DOC21/1027113-7

**EPA Advice on Environmental Impact Statement for proposed Jalco Manufacturing Facility,
Horsley Park (SSD 21190804)**

10 January 2022

Figure 3 Locations of Receptors

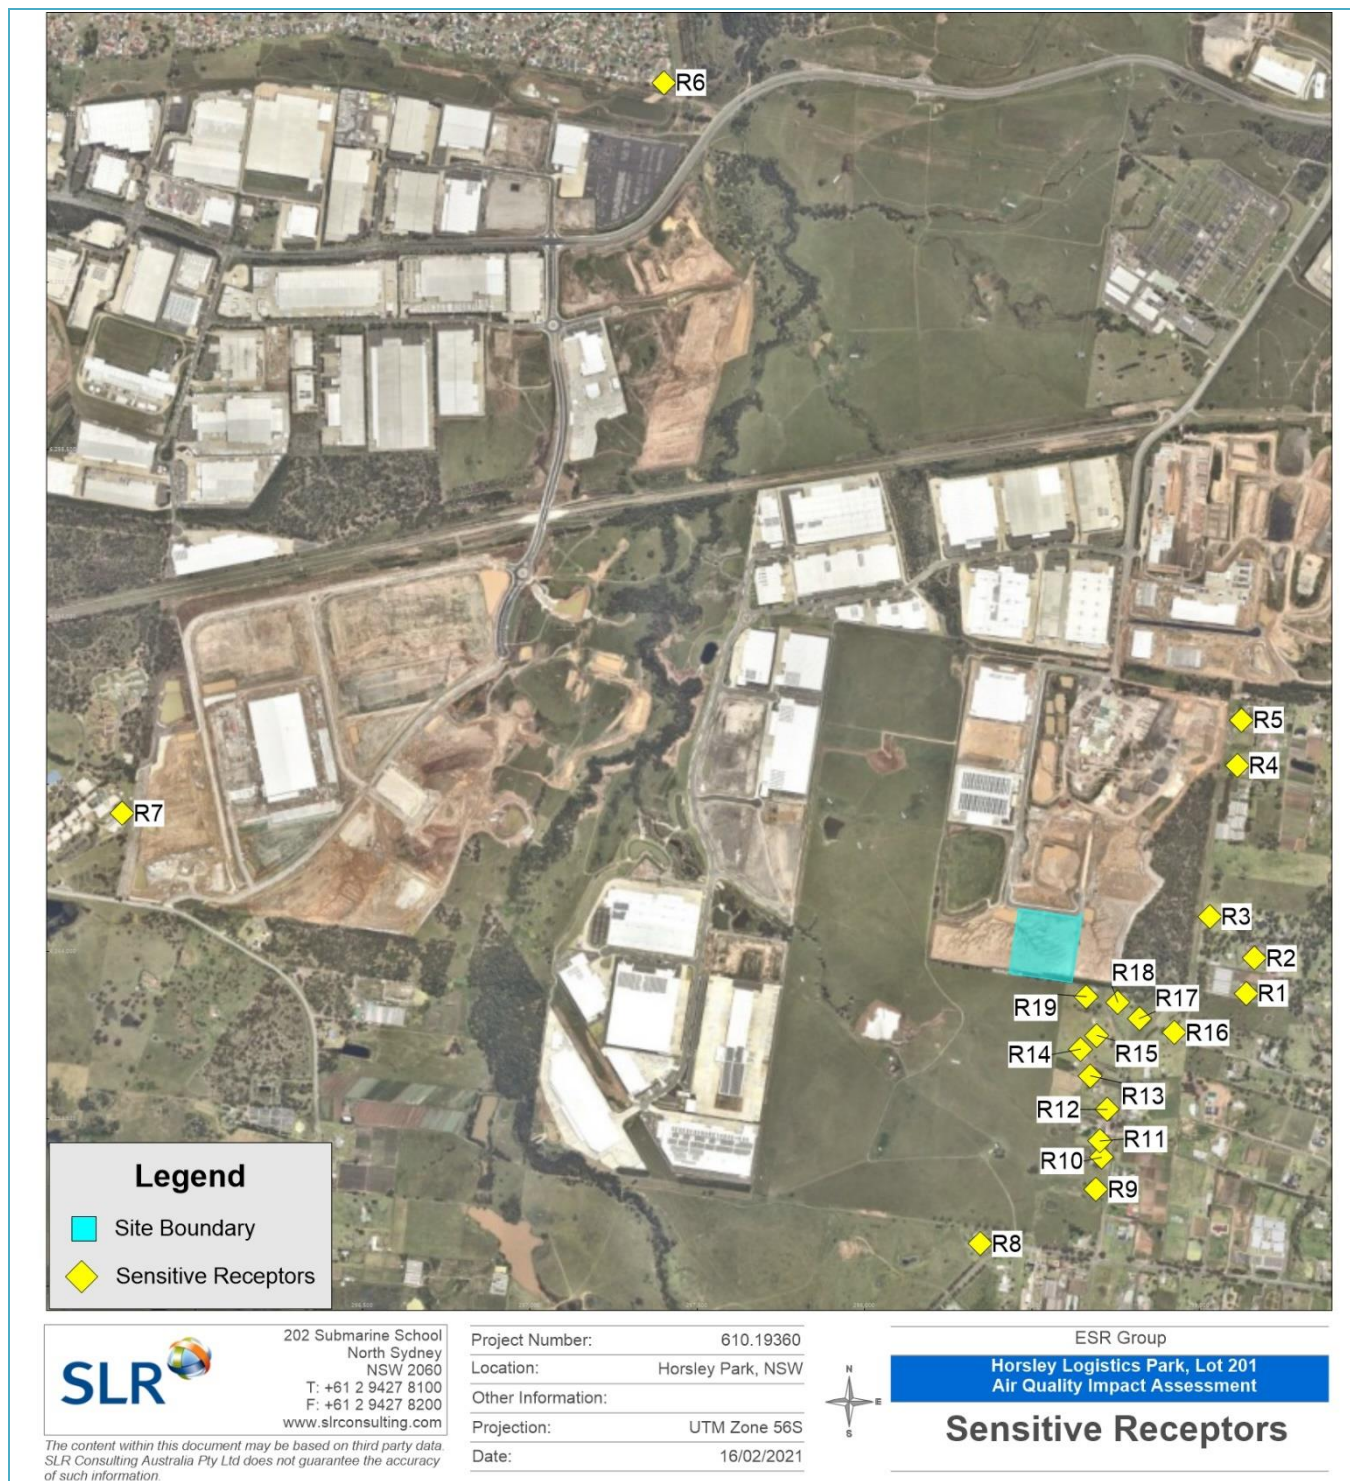
NIA Chapter 6.1.5 states that “noise levels have been assessed at the most-affected point at each residential property.” However, a review of NIA Figures 3 and 4 indicates that this may not be the case and it is not clear if the requirements of Chapter 2.6 of the Noise Policy for Industry have been met. For example, at NCA 2 Loc 2, the contour maps appear to show areas in the northwest of the property that may receive higher noise levels than where the assessment point was placed. The consultant must ensure that the assessment location has been placed at the worst affected location on or within the property boundary as defined within Section 2.6 of the NPfI.

EPA recommends that the receiver locations are reviewed and updated to be placed according to Section 2.6 of the Noise Policy for Industry and the assessment updated accordingly.

Figure 14 Odour Impacts

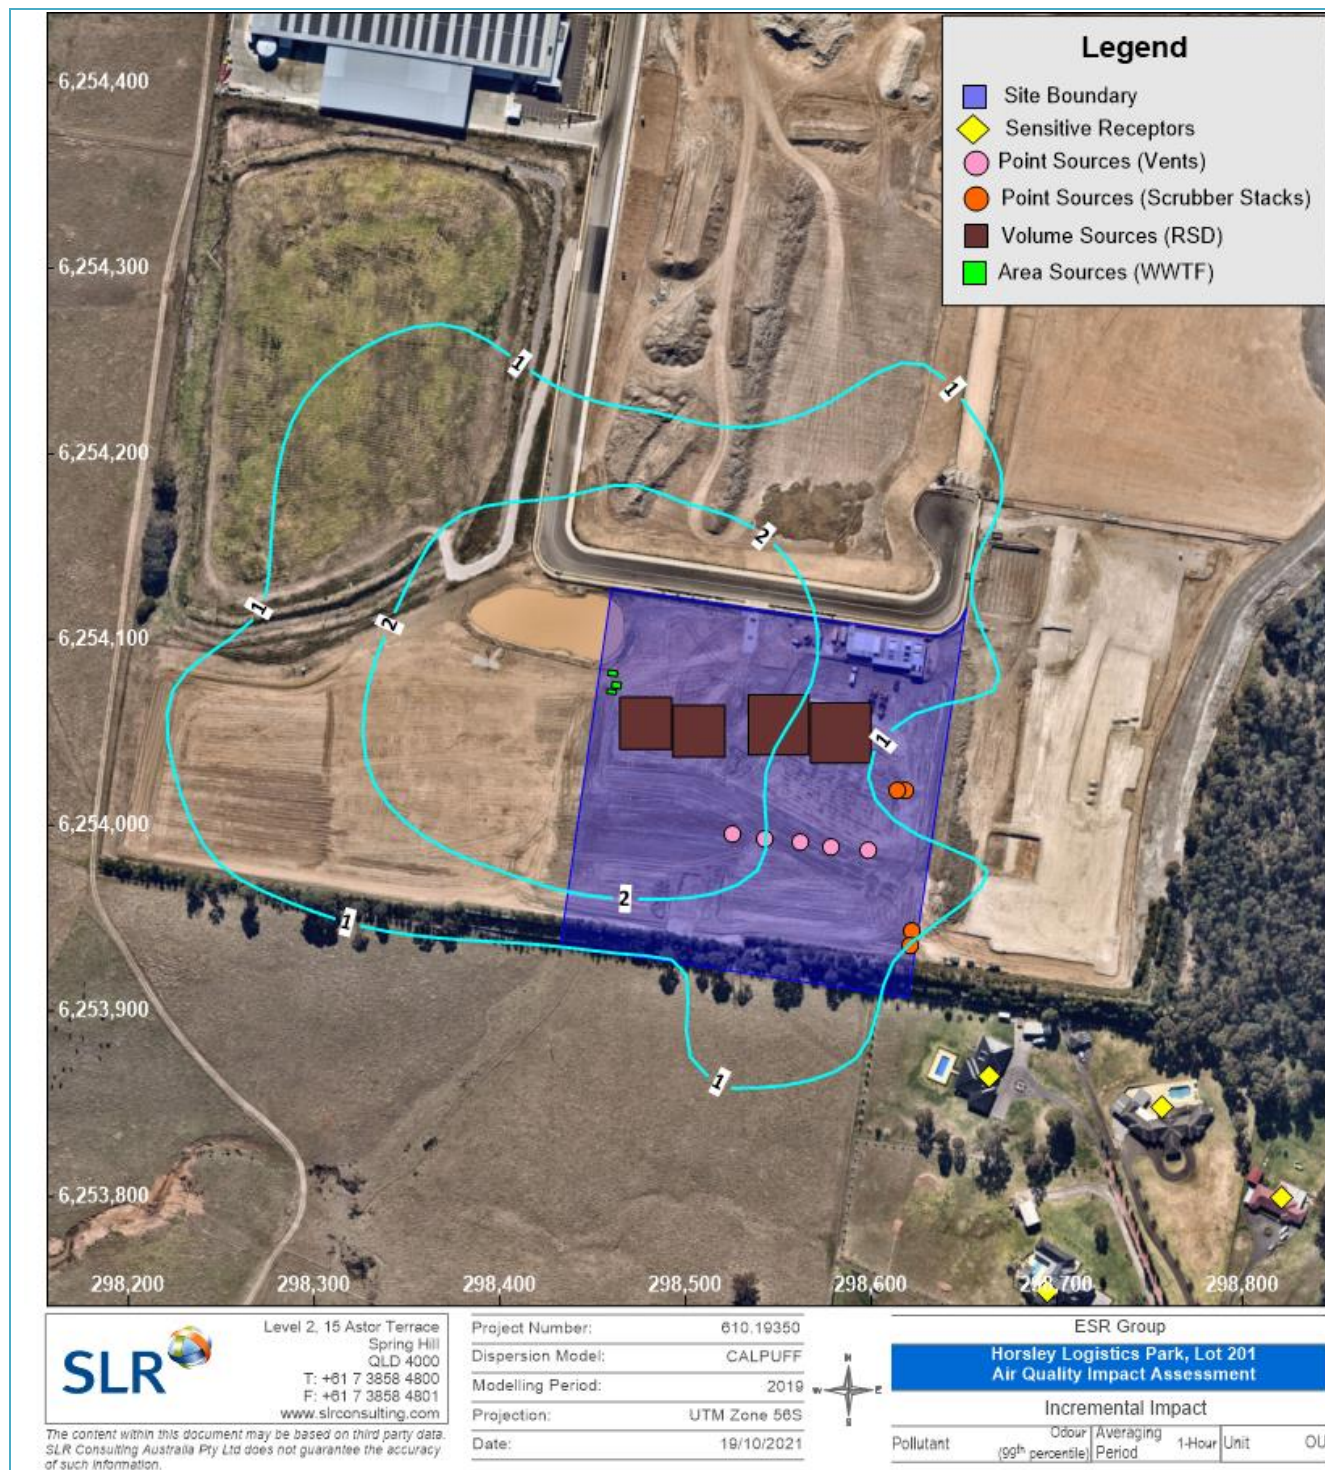
From Figure 14 of the AQIA, the proposed design of the plant has positioned the outlet of the scrubbers in close proximity to neighbouring residential receptors, with the most southern scrubber outlets being within 100m of receptor 19.

EPA considers the location and design of activities and emission points should be carefully considered in the design phase of the planning process to ensure the best environmental outcomes. It is usually more difficult and costly to address odour impacts retrospectively. Where there are opportunities to optimise the design of the facility during the design stage, this should be preferentially considered, rather than waiting until the plant is operational.

EPA recommends the design of the facility be reviewed to ensure all activities and emission sources are optimally located to minimise the potential for off-site impacts occurring.
